May 9, 2024

**Subject: Meineke Car Care  
5901 Carmel Dr NE  
C18D049**

C3 BIKE RACK ELEVATION
1/2\"/>

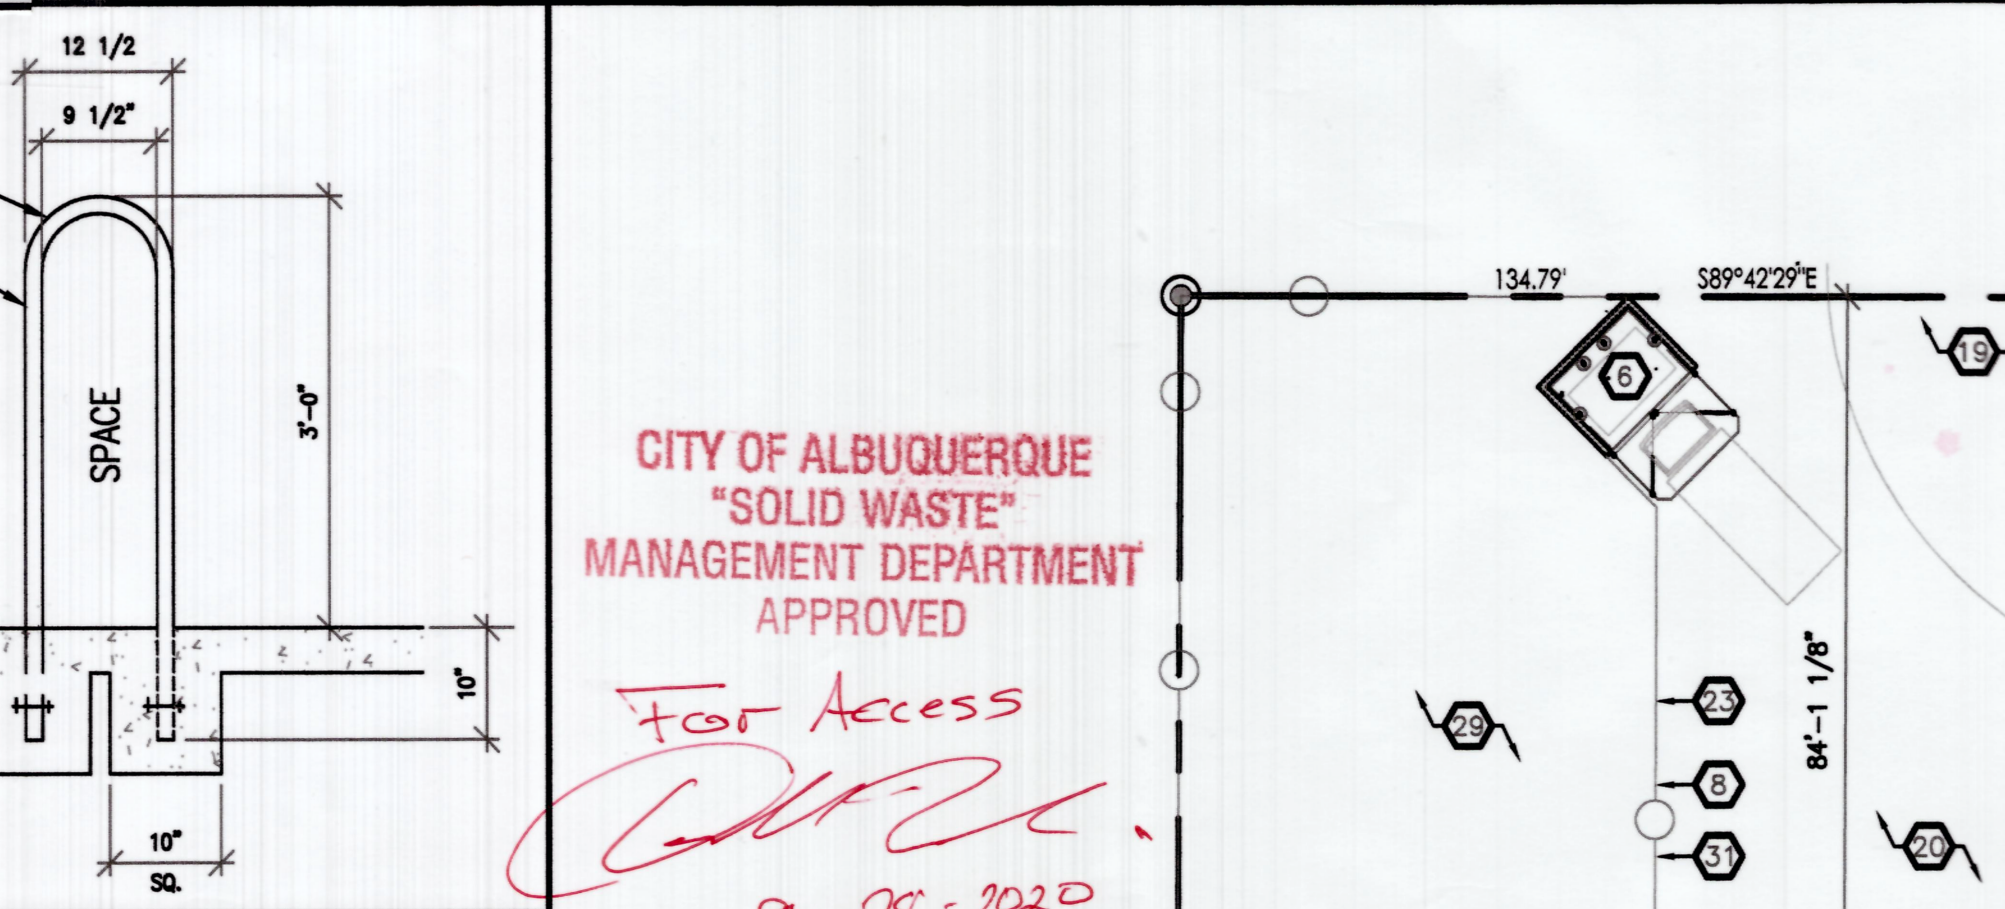
Dear Curtis,  
RBA has no problem with the style and location of the bike racks.
